16 March 2009

PLANNING APPLICATION FOR EXTERNAL ALTERATIONS TO FACILITATE CONVERSION OF EXISTING RETAIL WAREHOUSE UNIT INTO FOUR UNITS. UNIT 2 THE PEEL CENTRE, HARBOROUGH HILL ROAD, BARNSELY. APPLICATION REF 2009/0194

As discussed and agreed at the end of the meeting, I enclose 4 copies each of revised drawing nos MH521-00 Rev B and MH521-02 Rev C, both of which show unit 2 converted into three units rather than four, with none of the units being less than 930 sqm (10,000 sqft).

Drawing No.	MH521-02	Revision	C
Scales	AS SHOWN	Date	MAR '09
Drawn	SOR	Checked	GB

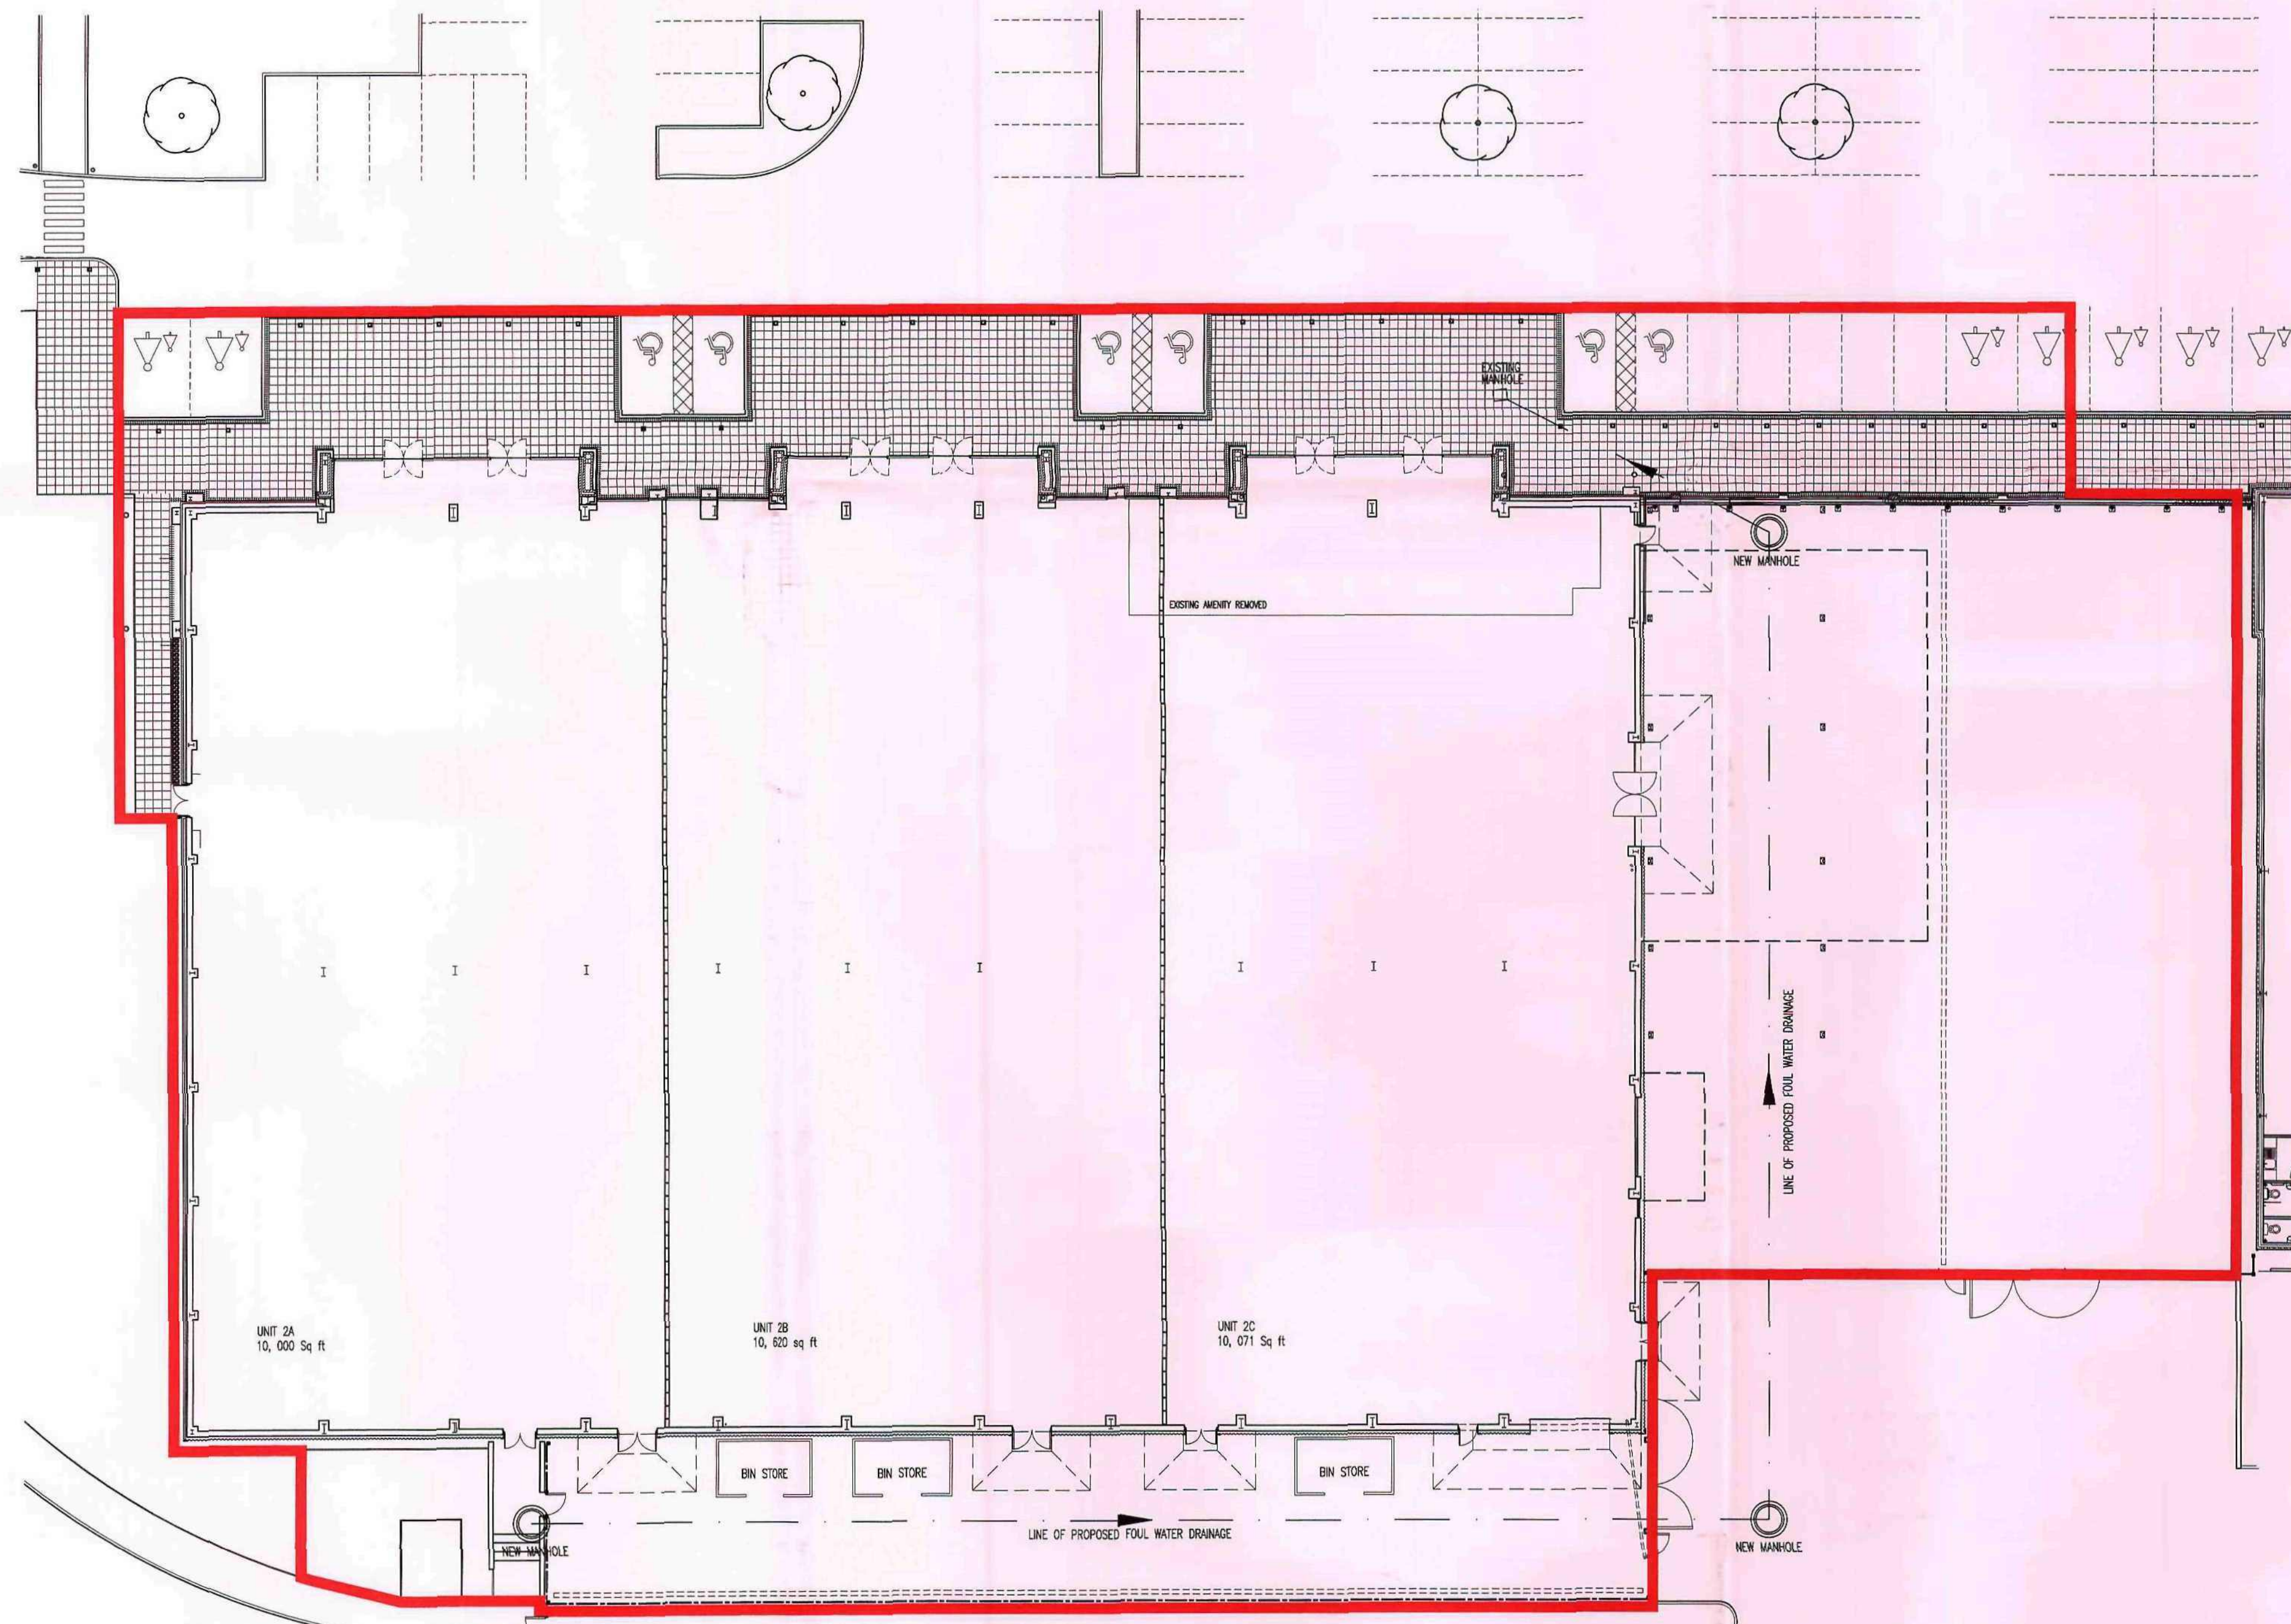
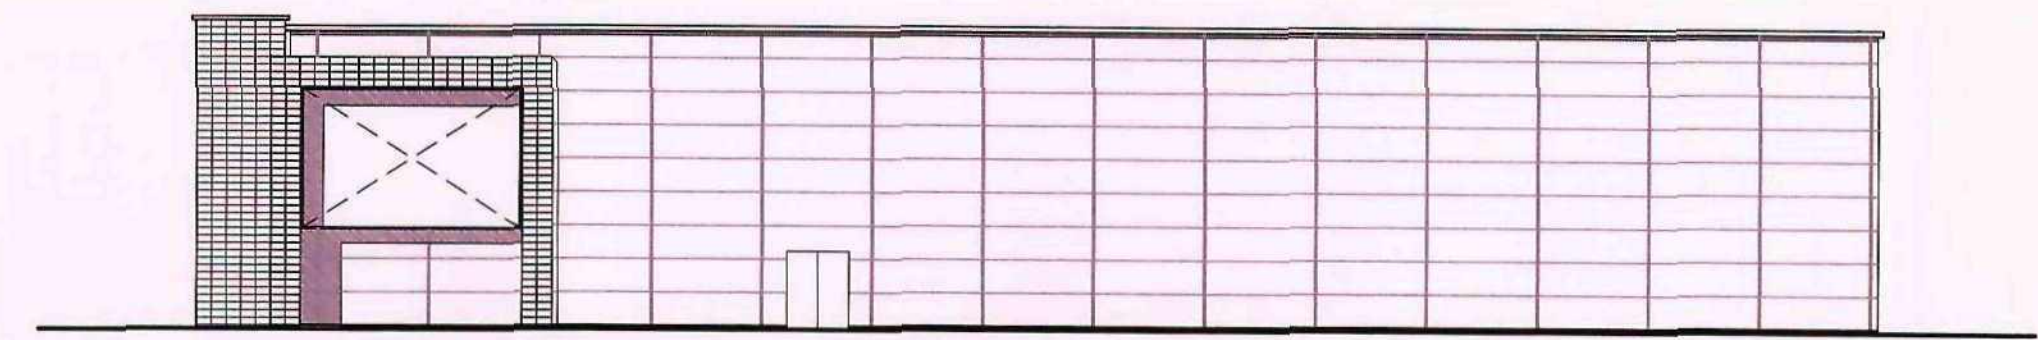
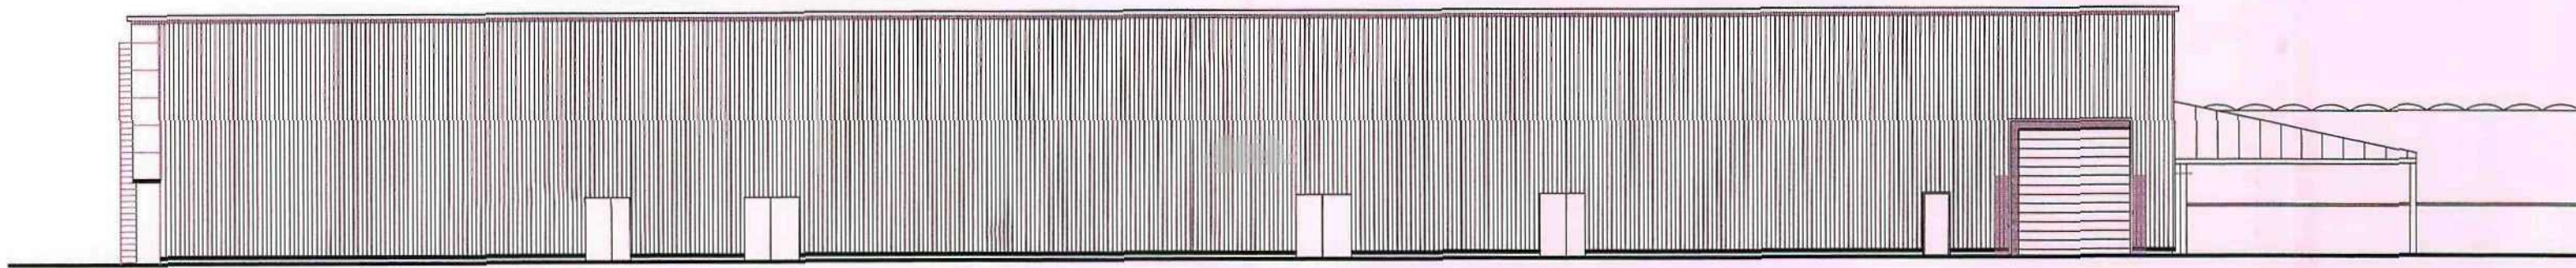
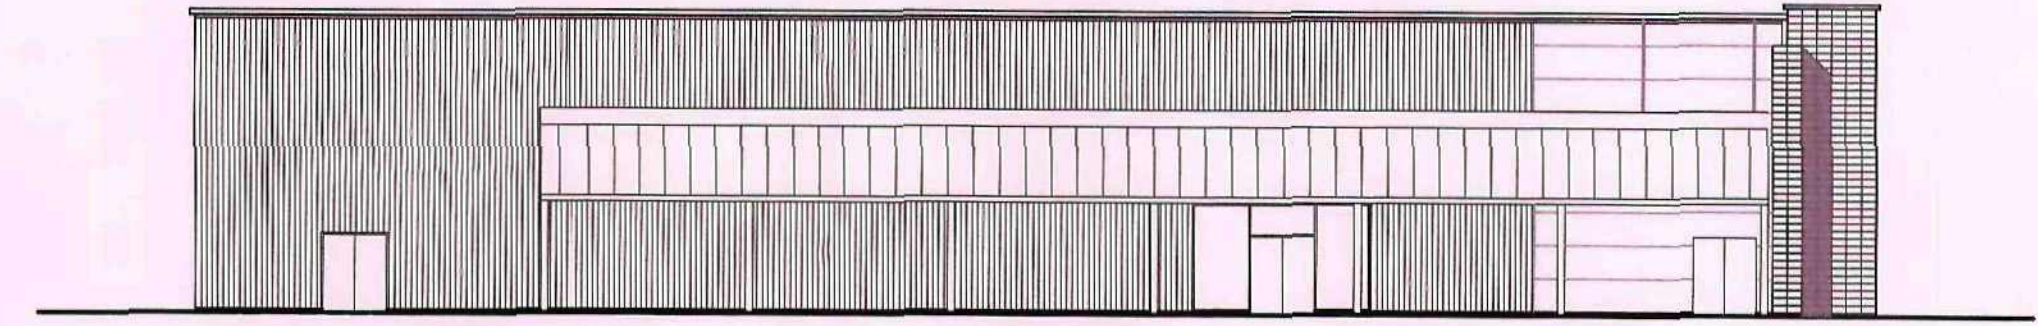
Also as agreed at the meeting, the new end unit 2C is shown with a new loading doorway directly onto the service area, meaning it can be serviced through this new doorway or through the existing rear service doorway which will be retained for flexibility.
